KIRKLEES METROPOLITAN COUNCIL INVESTMENT & REGENERATION SERVICE

DELEGATED DECISION FOR DISCHARGE OF CONDITION A.4 - NOTIFICATION OF A PROPOSED ENLARGEMENT TO DWELLINGHOUSE

Reference no.	2025/HH/90953/W
Site Address	90, Kaye Lane, Almondbury, Huddersfield, HD5 8XU
Description	The proposal is for erection of single storey rear extension. The extension projects 4.5m beyond the rear wall of the original dwellinghouse. the maximum height of the extension is 2.7m, the height of the eaves of the extension is 2.7m
Recommending Officer	Molly Storer

Drawing Title\_  
AS EXISTING\_ GROUND FLOOR + ROOF PLAN

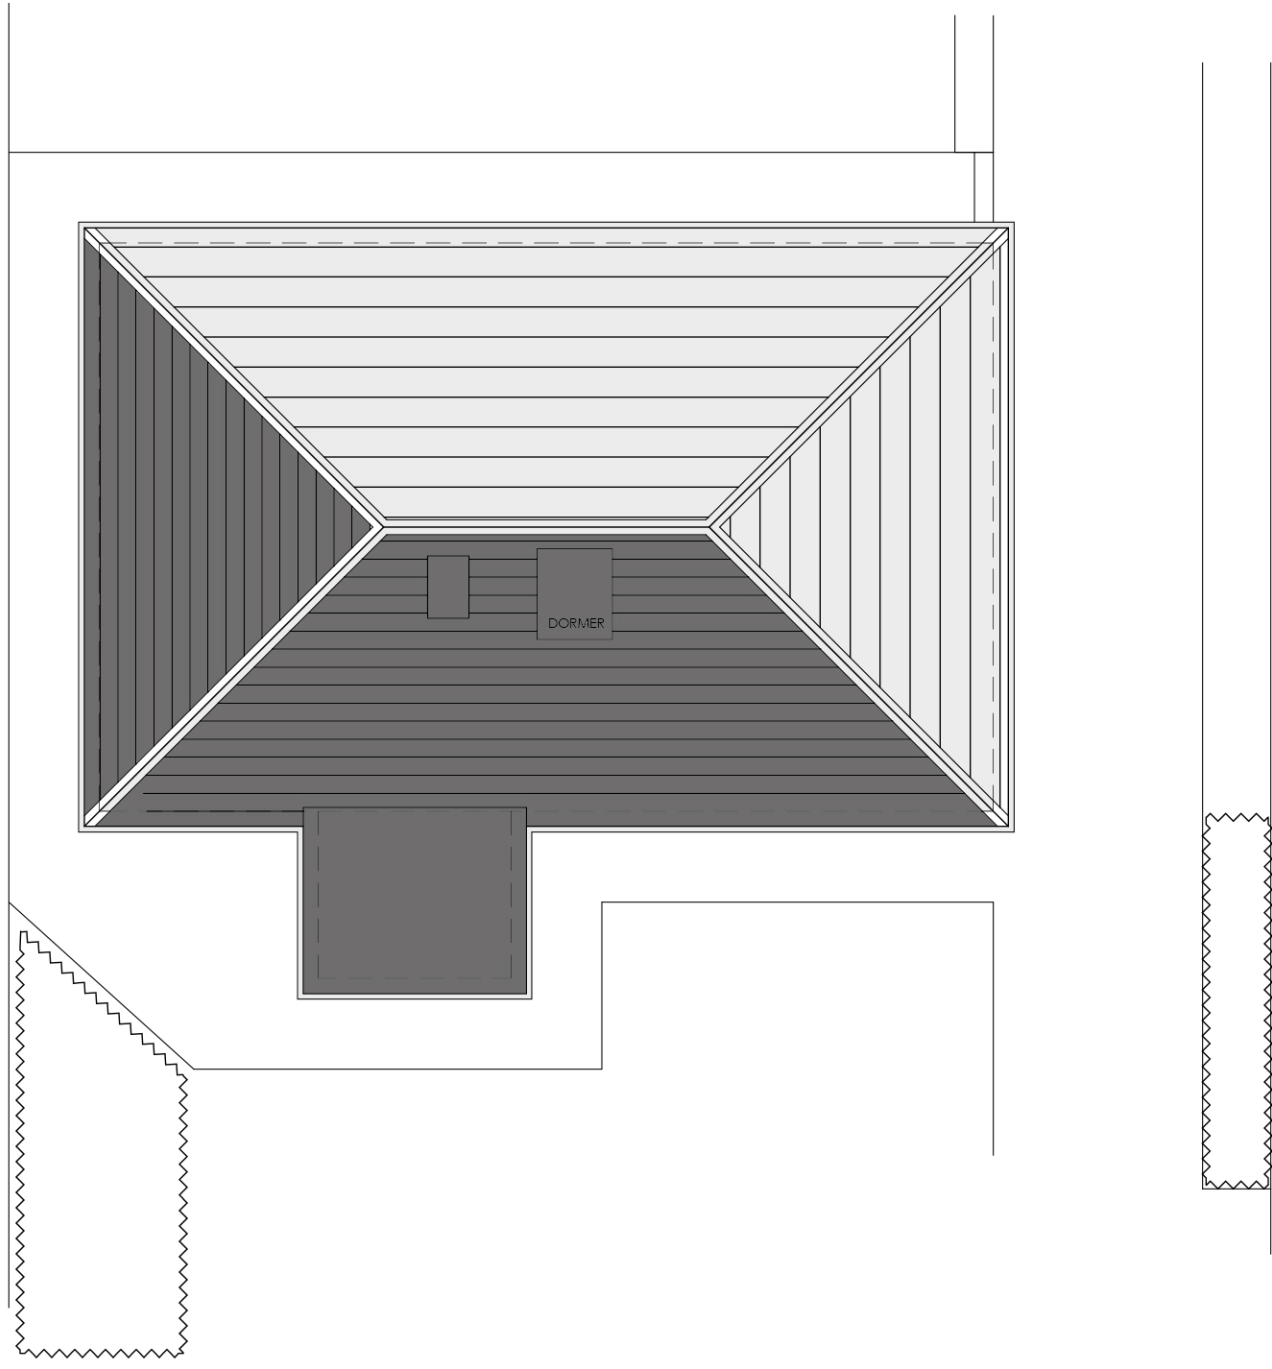
Plans show that there is a projecting reward element to the property which appears on the Council's Ordnance Plotting sheets although it appears to have been a drawn addition to the original survey. Moreover, it also appears the construction of the property was carried out pursuant to a pre-1974 planning permission for which plans are not available prior to determination. Historic maps held by the Council indicate the dwellinghouse was a replacement of a previous dwelling sited closer to Kaye Lane and as such offer no evidence to suggest the rearward projection is original to the dwellinghouse. The matching stonework of the rear projection offers some suggestion the projection was built at the same time as the dwellinghouse although this is not conclusive.

Or the purposes of Class A.4, it is considered there is no clear evidence to suggest in the opinion of the Local Planning Authority that the rearward projection is original of the dwellinghouse. It is considered prudent to add a footnote advising the potential of the proposed enlargement exceeding the limitations of Class A and in particular sub-paragraph A.1(j).

NOTE: It is noted that the existing dwellinghouse features a rearward porch projection. It is advised that steps are taken to confirm whether or not this projection was constructed with the dwellinghouse. If the rearward projection is original to the dwellinghouse it may affect the lawfulness of the proposed enlargement as it would be considered to project beyond a side elevation of part of the original dwellinghouse. As such the proposed enlargement would exceed the limitations as set out in sub-paragraph A.1(j) of Class A, Part 1 of Schedule 2 of the Town and Country Planning (General Permitted Development)(England) Order 2015(as amended). If you wish to ascertain the lawfulness of the proposed enlargement it is advised you consider applying for a certificate of lawful development under section 192 of the Town and Country Planning Act 1990 and submit evidence to demonstrate the existing rear porch projection was not original to the dwellinghouse.
